DRB Application No.: 05DRB-00670 (SBP)
Project Name: JOURNAL CENTER, PH 2 UNIT 1
Agent: JOHN KLEE

**April 27, 2005
DRB Comments**

RE: Journal Center, Phase 2, Unit1/ minor SDBP

COMPANY SIGN ELEVATION
SCALE: 1/4"=1'-0"

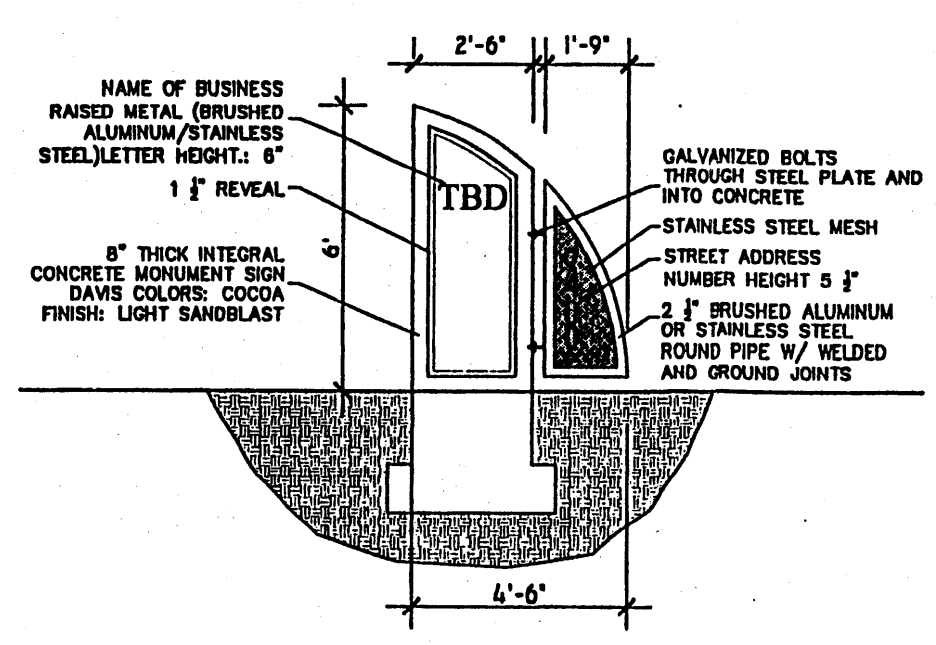
Elevation drawing of sign with dimensions , materials, square footage and colors are required. Is there any illumination on the sign? Please clarify.

SHEET TITLE: SITE PLAN FOR BLDG. PERMIT
DRAWN BY: AU, RI

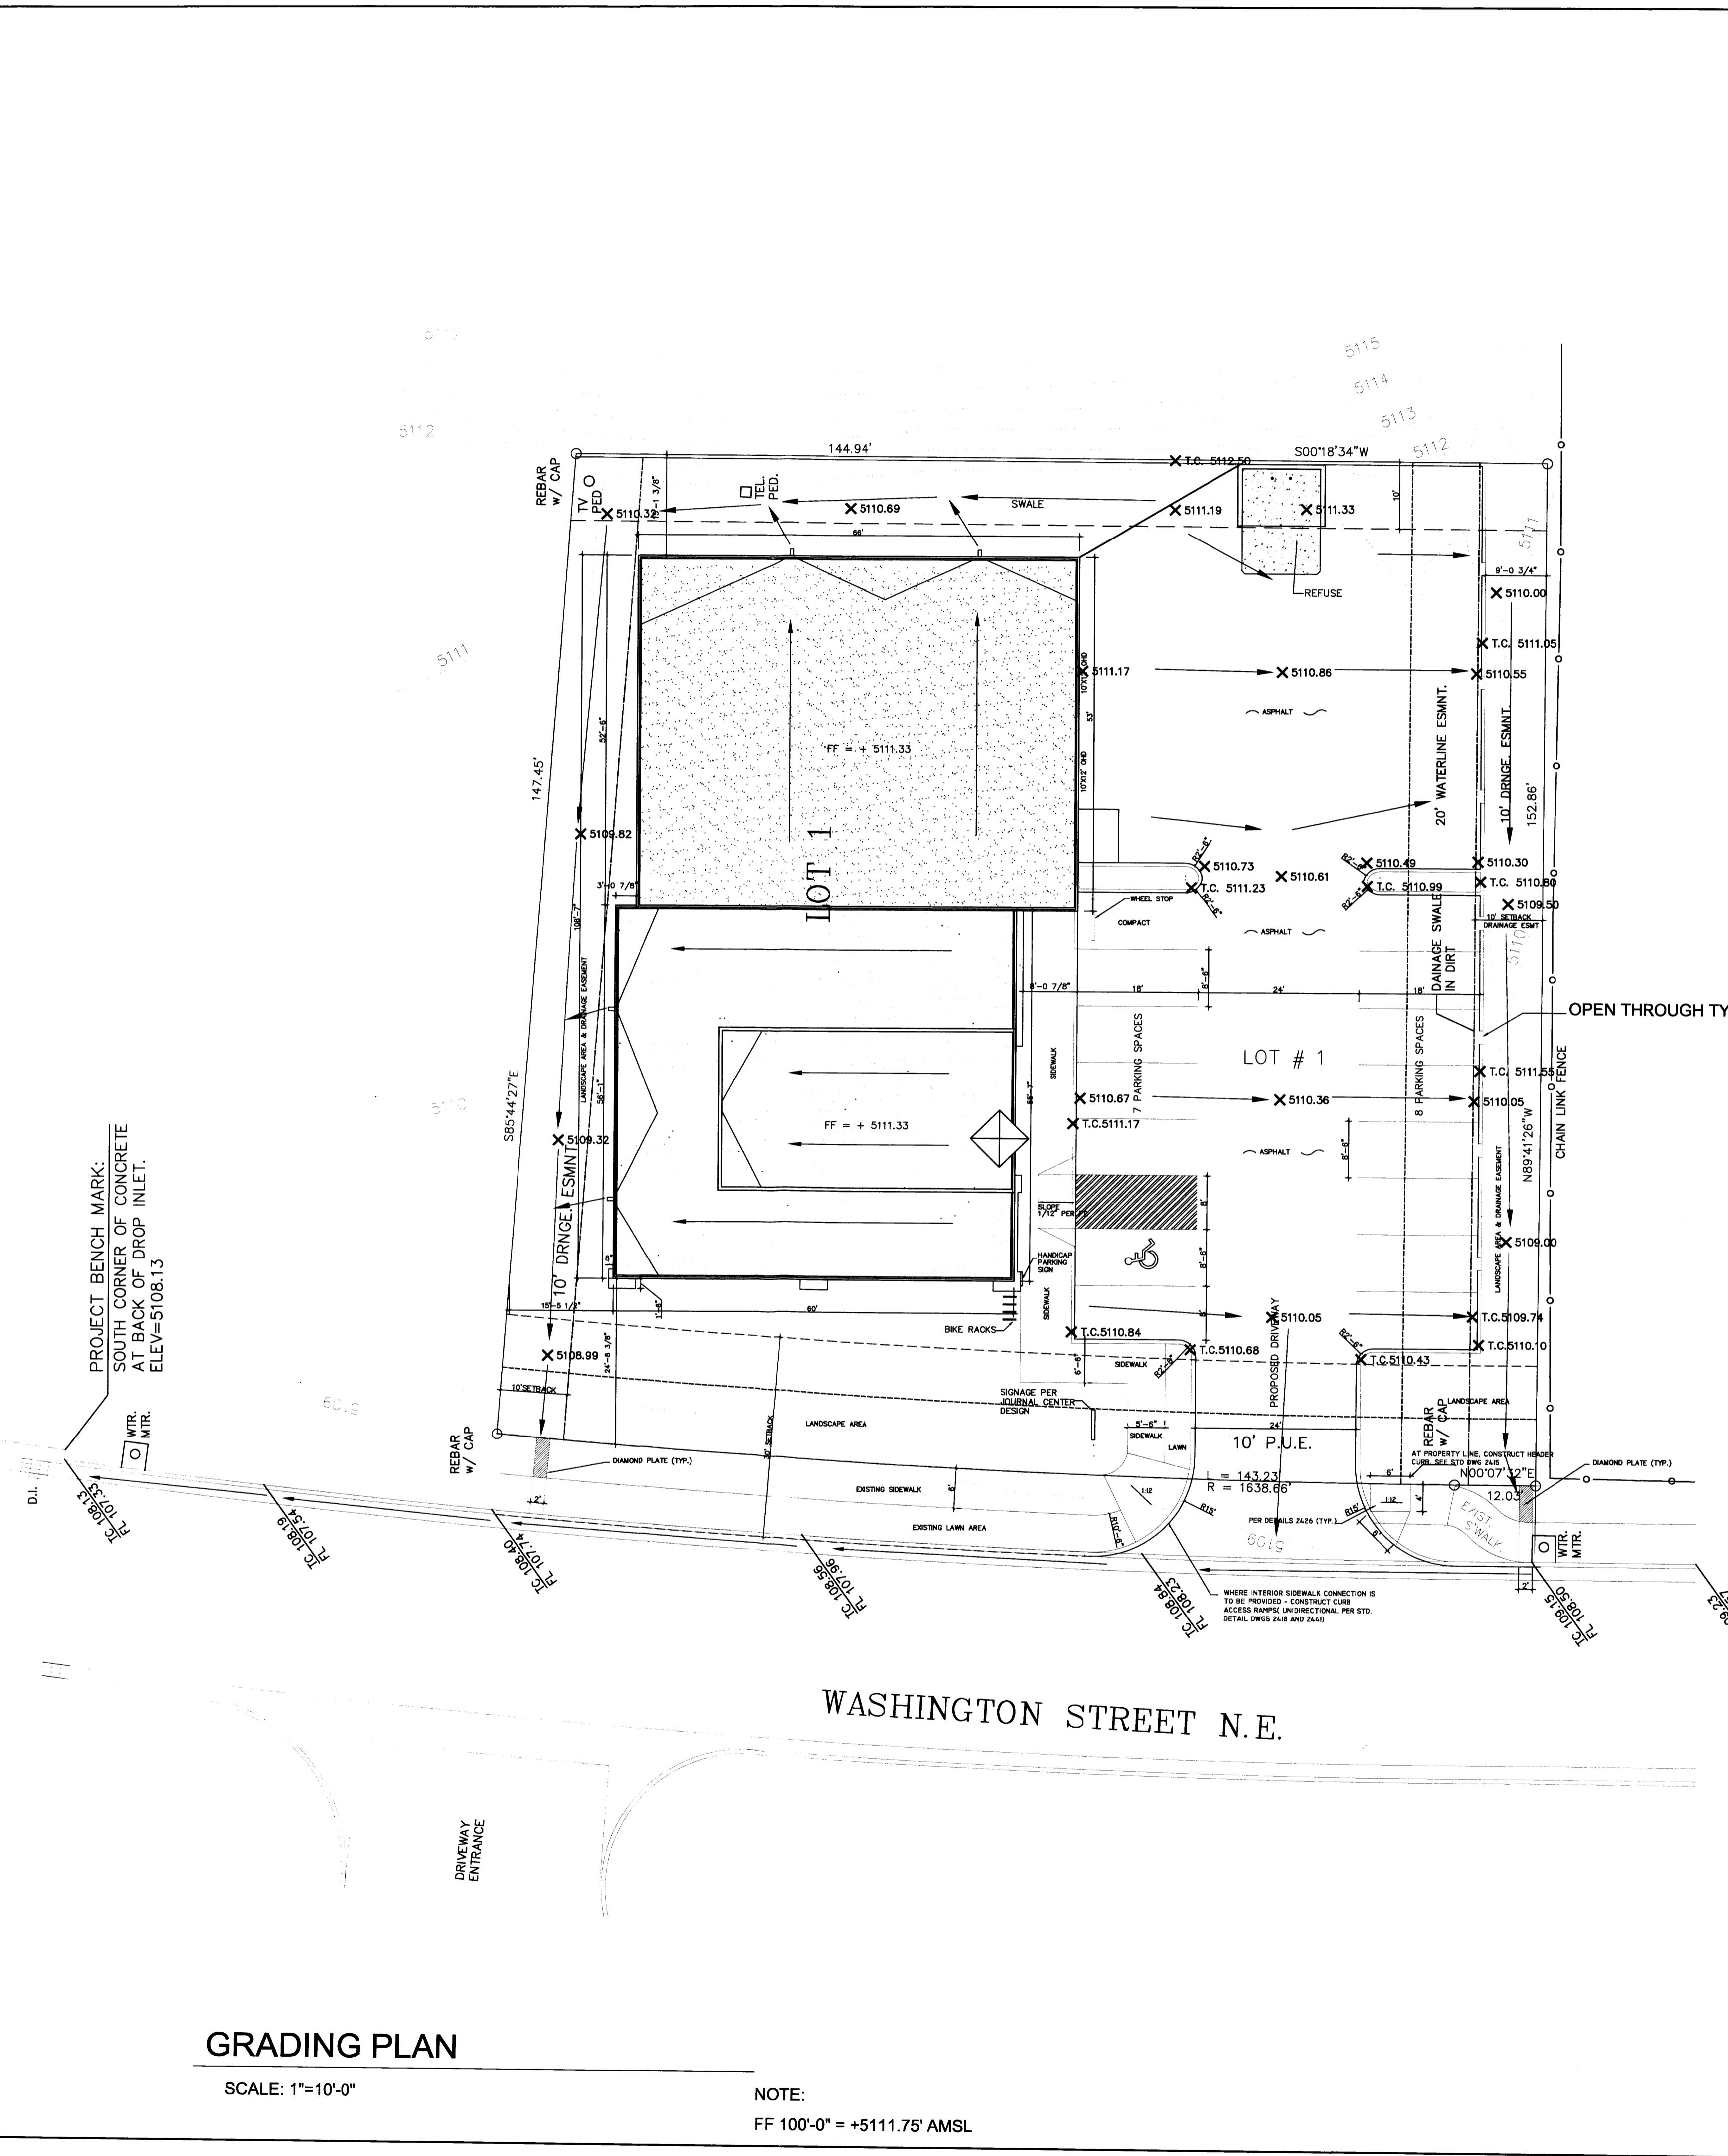
Title Block Should read "Site Plan for Building Permit".

Typical drawings are not labeled site plan.

Please identify any easements, existing or proposed.

Please identify the square footage and use of each building.

SOUTH ELEVATION

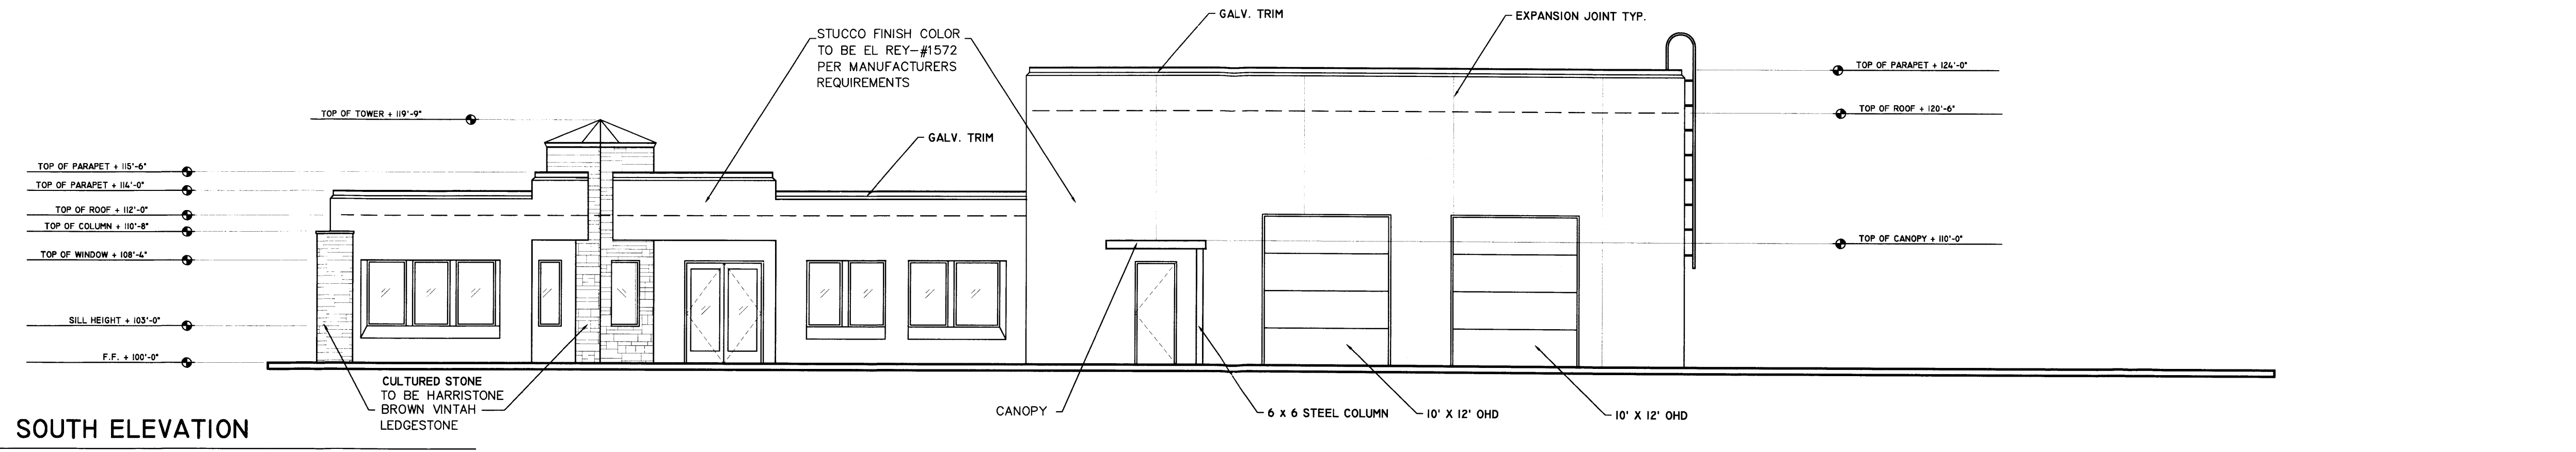
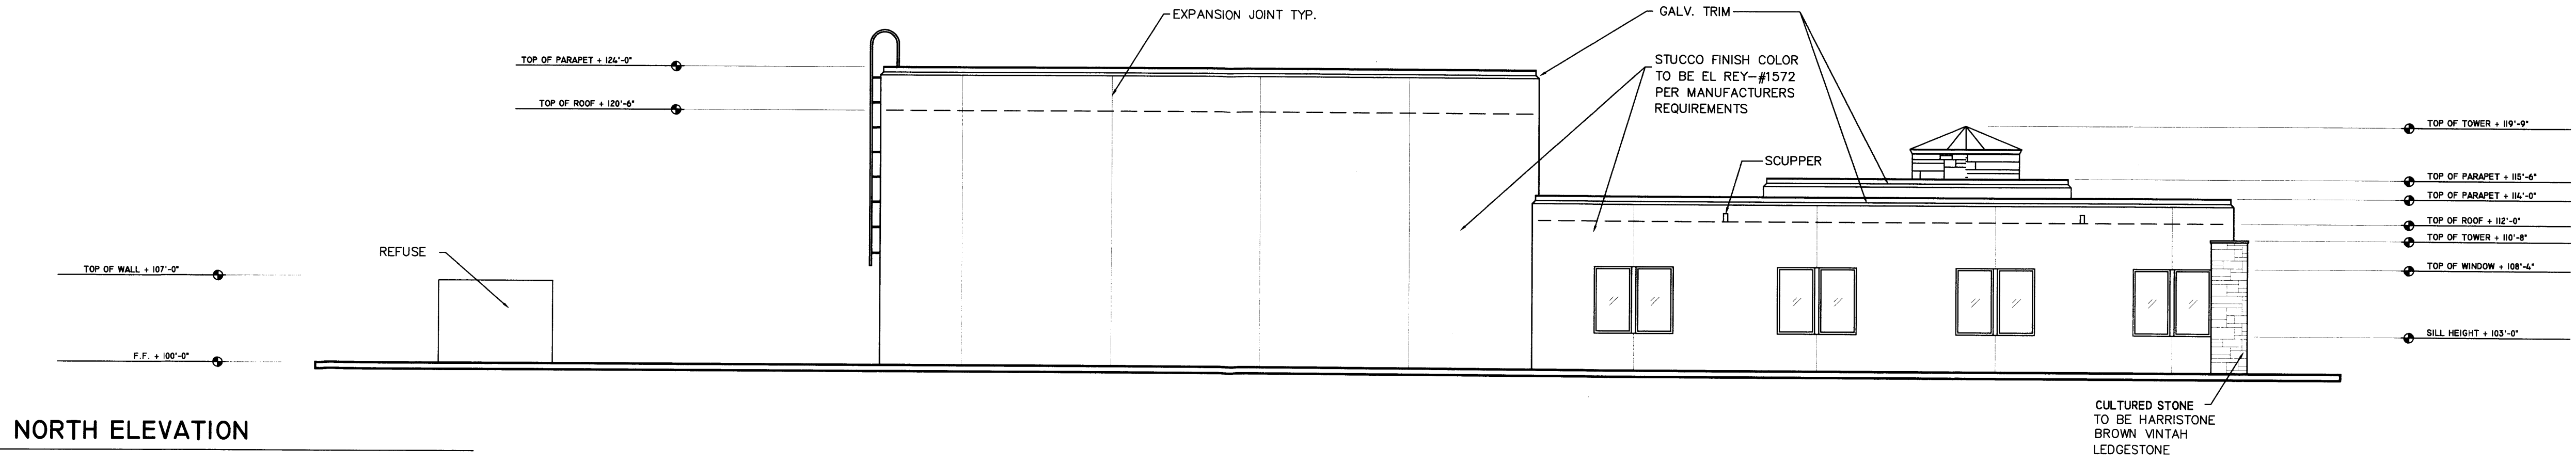
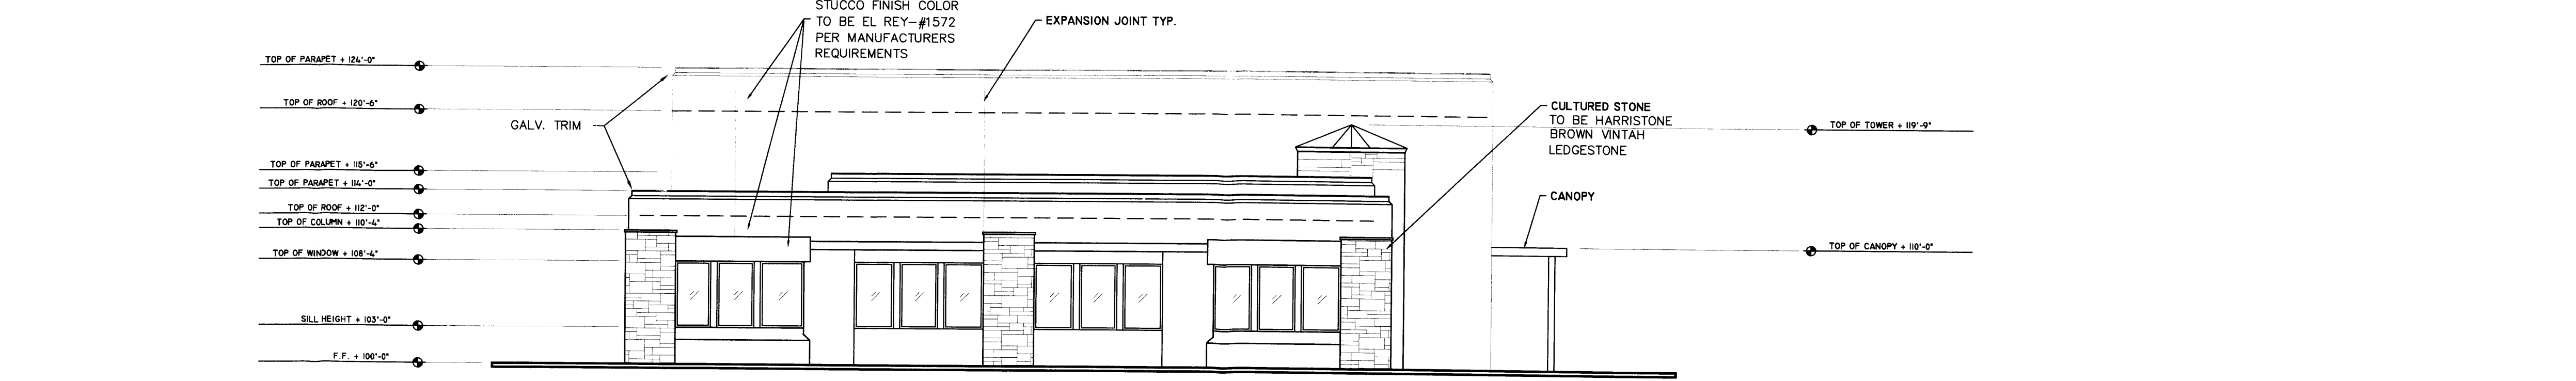
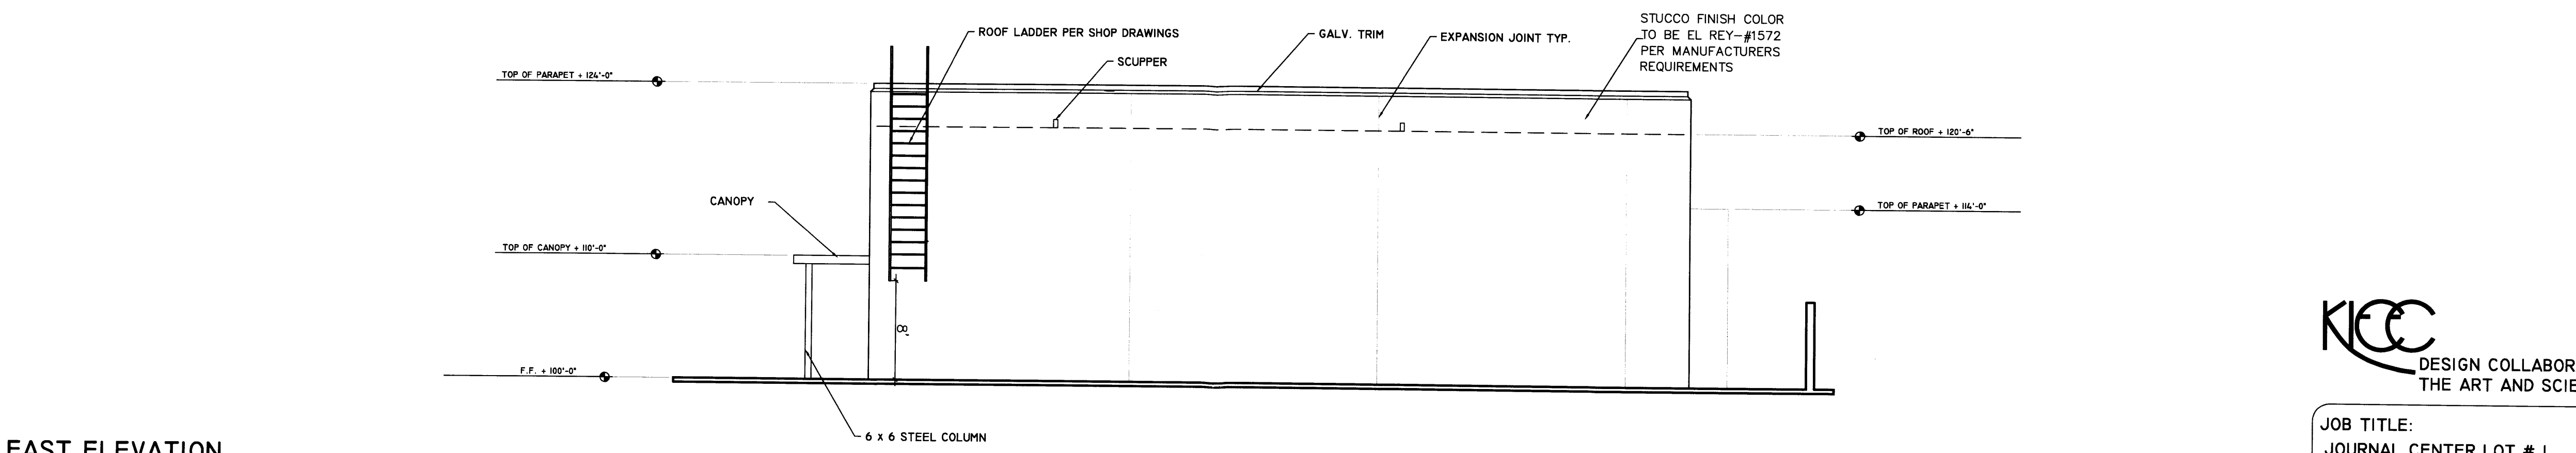
Colors on elevation sheet are required.
